Environmental Health Division
1675 W. Garden of the Gods Road
Suite 2044
Colorado Springs, CO 80907
(719) 578-3199 *phone*
(719) 578-3188 *fax*
www.elpasocountyhealth.org

Fall Mountain Farm, PPR-22-46

Please accept the following comments from El Paso County Public Health for the request referenced above:

SHEET TITLE: **SITE DEVELOPMENT PLAN**

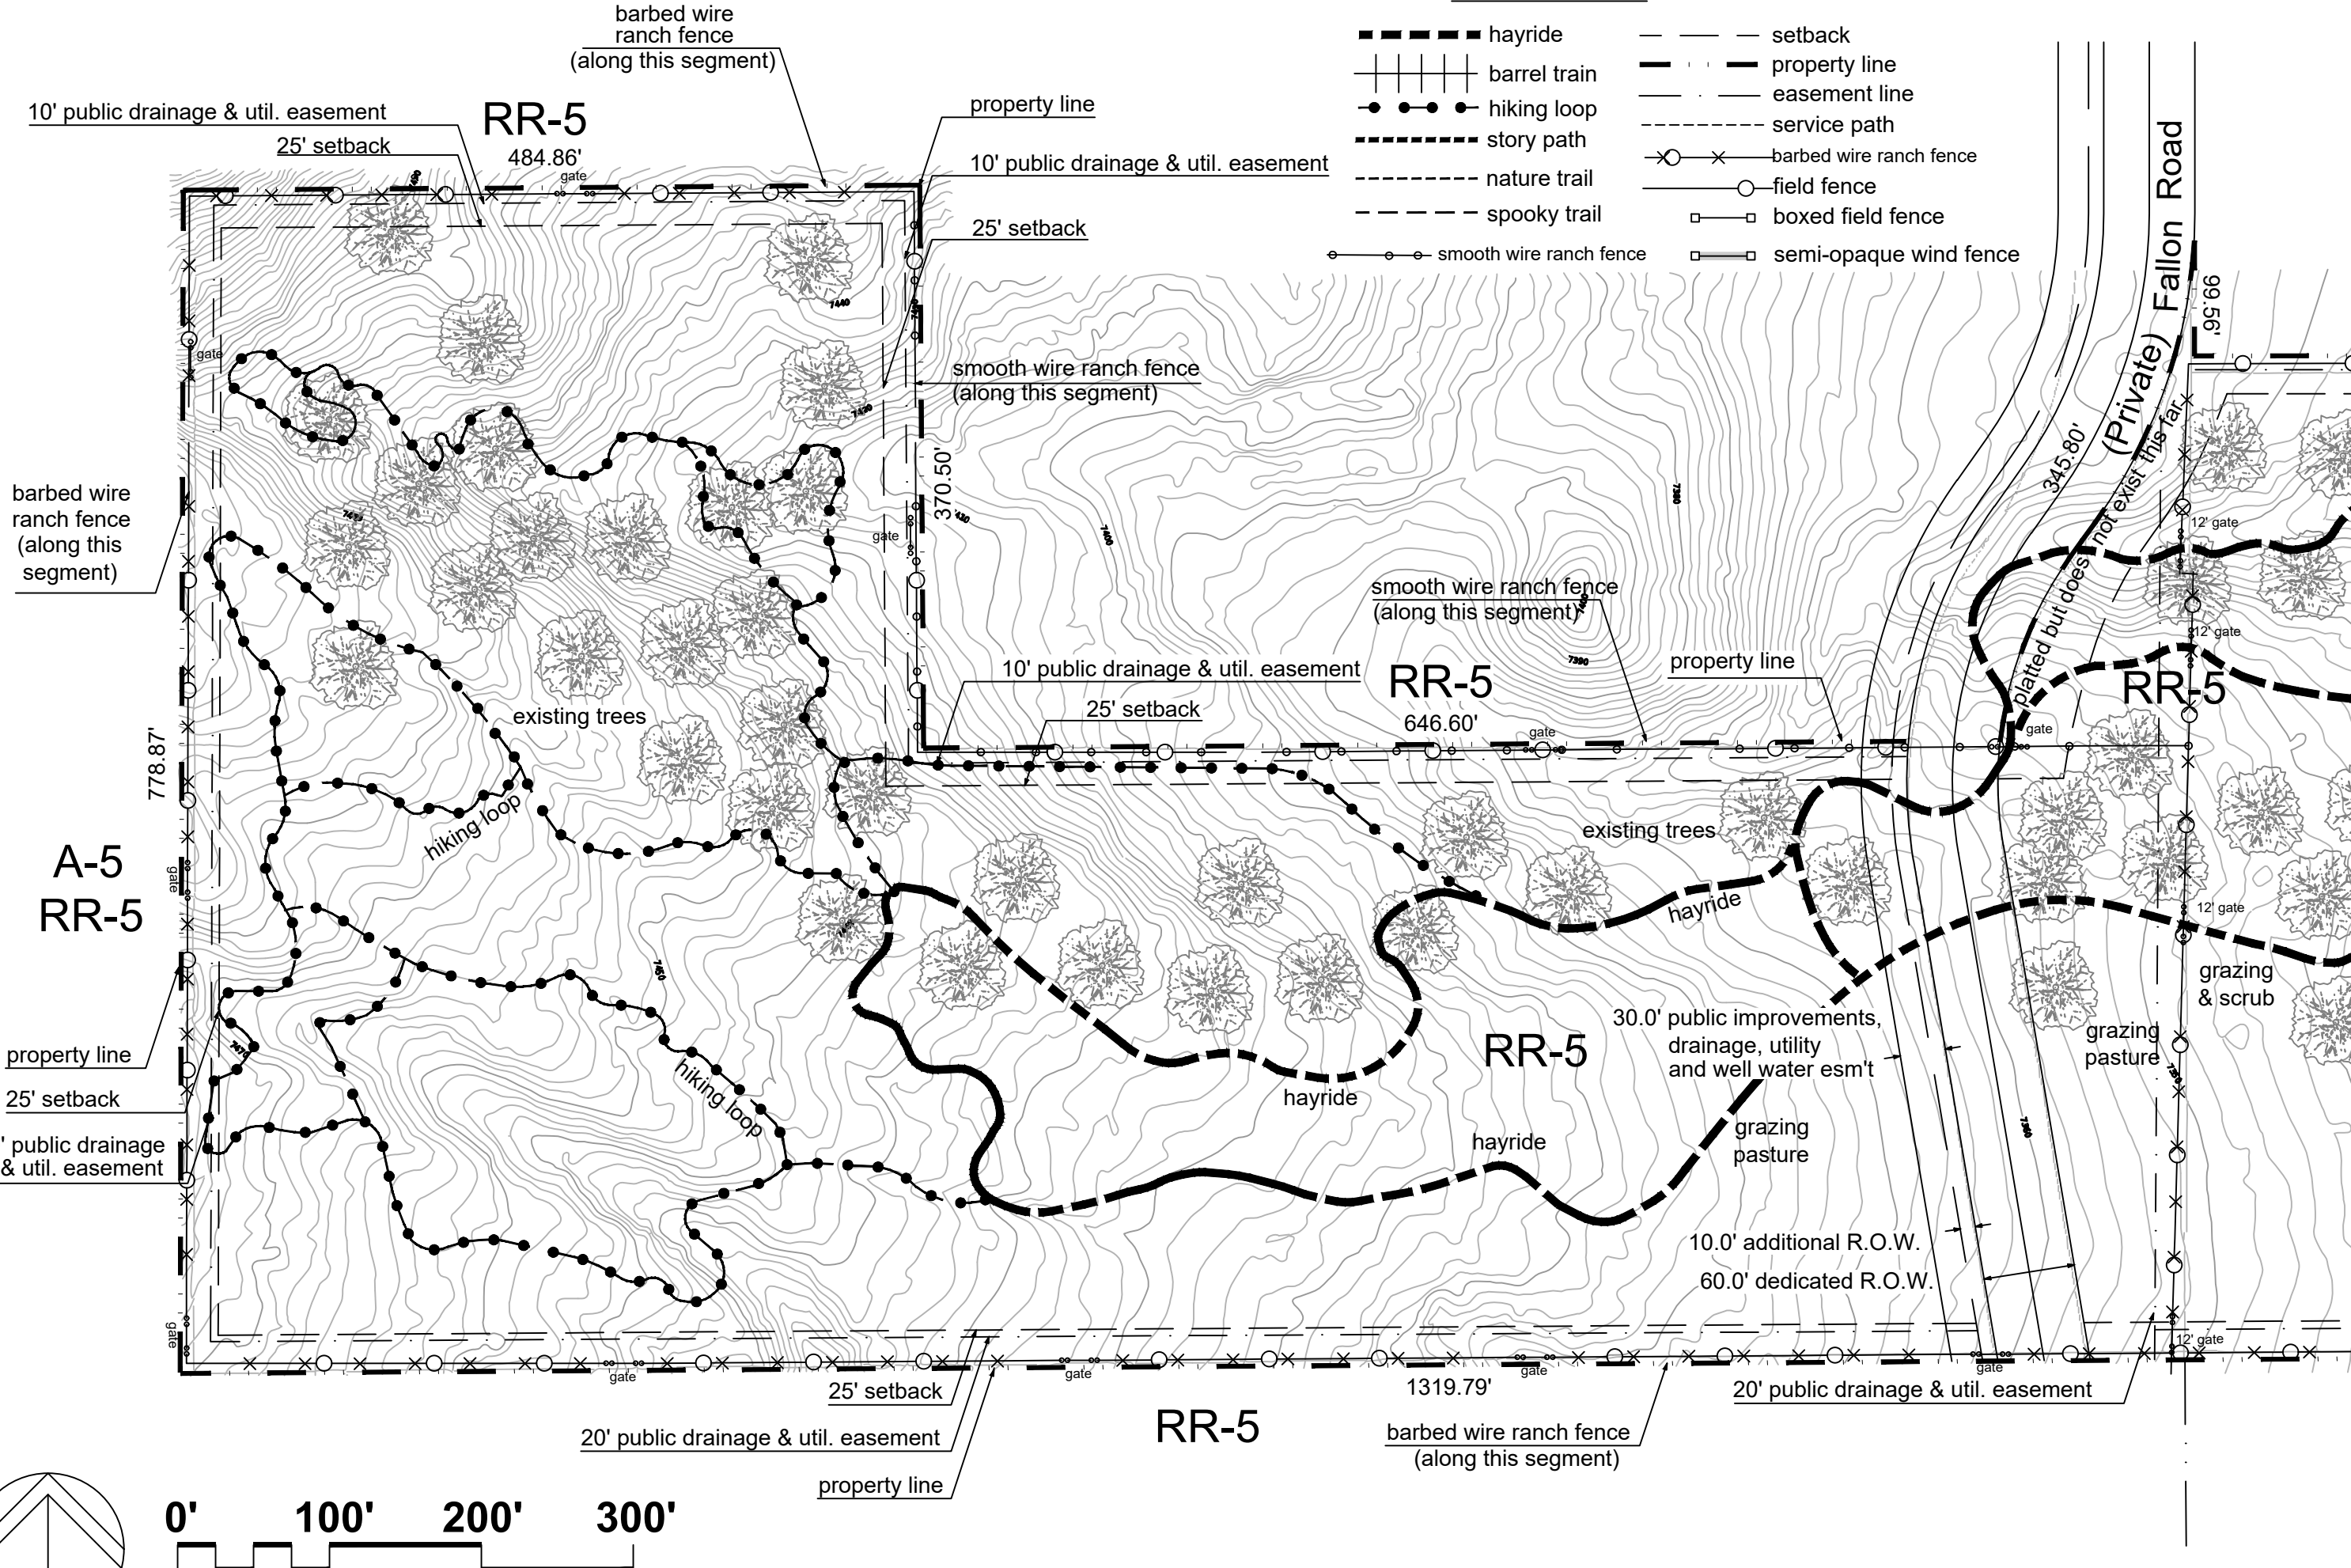
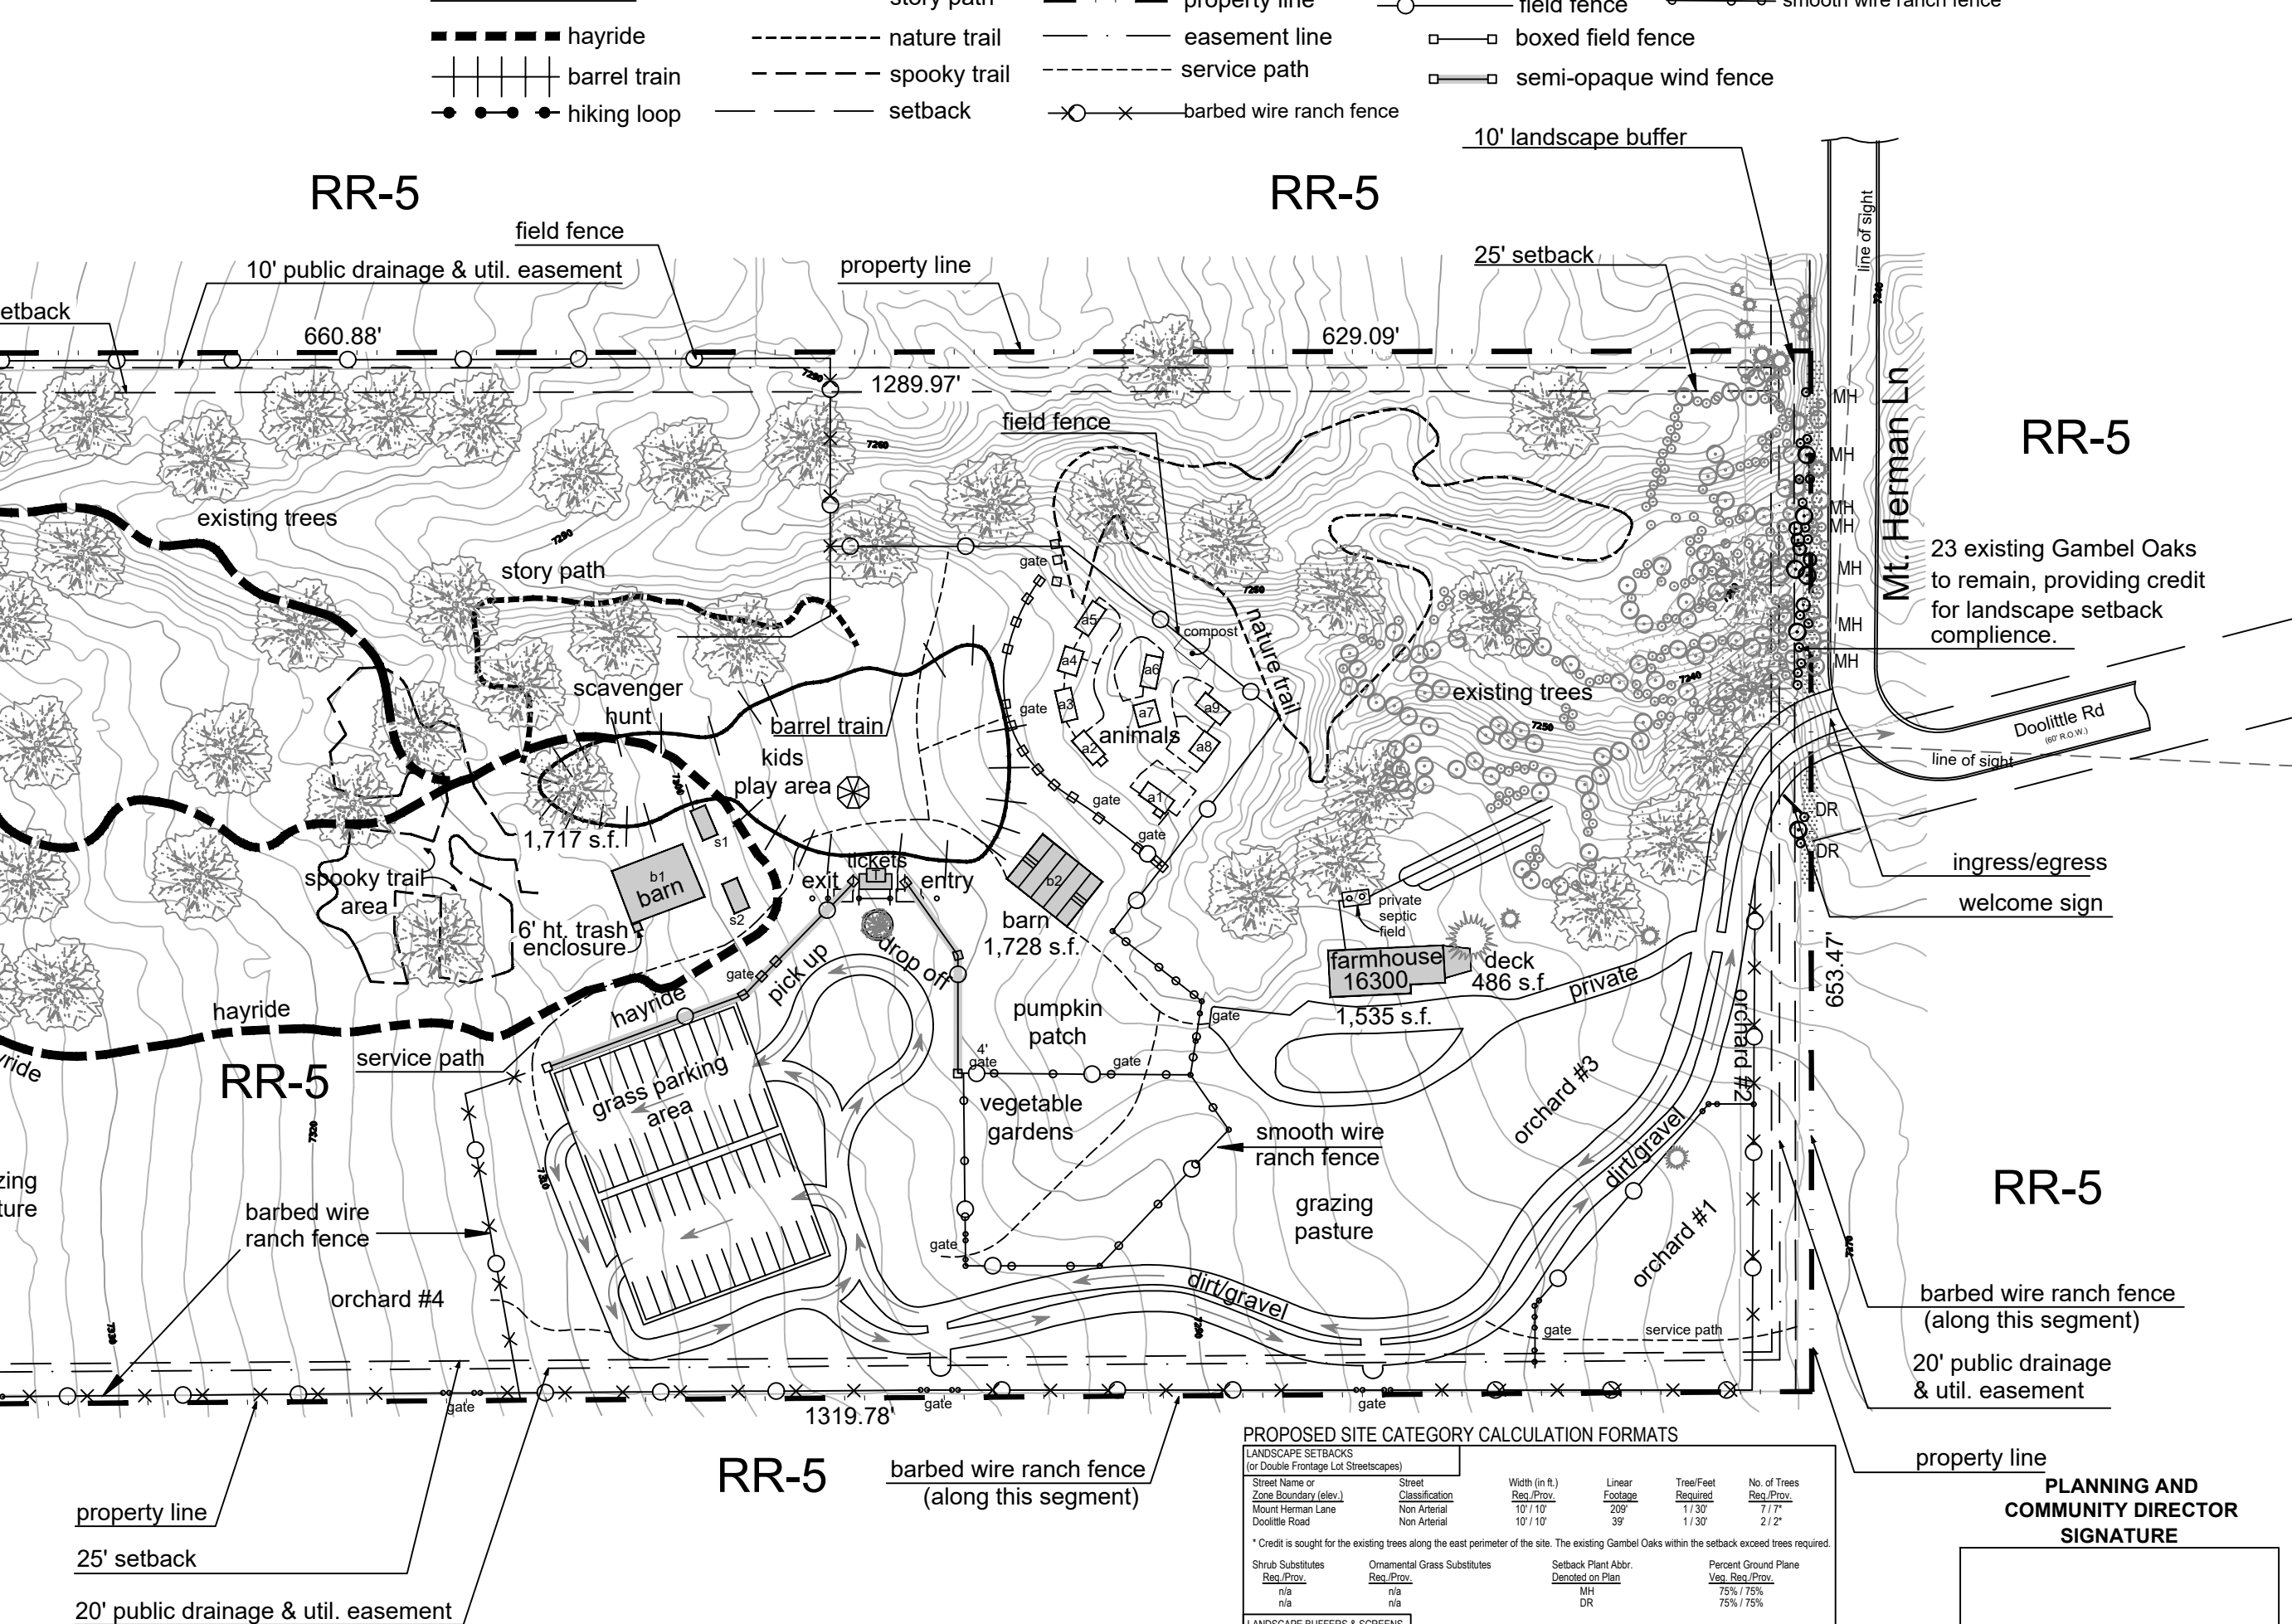
- Animal waste must be collected and removed to minimize odors, and insect/rodent attraction.
- The existing residence is connected to an onsite wastewater treatment system (OWTS) installed and approved in 1987 for a 4-bedroom house. Please locate the OWTS soil treatment area and make sure traffic and parking will not be in proximity to the OWTS.
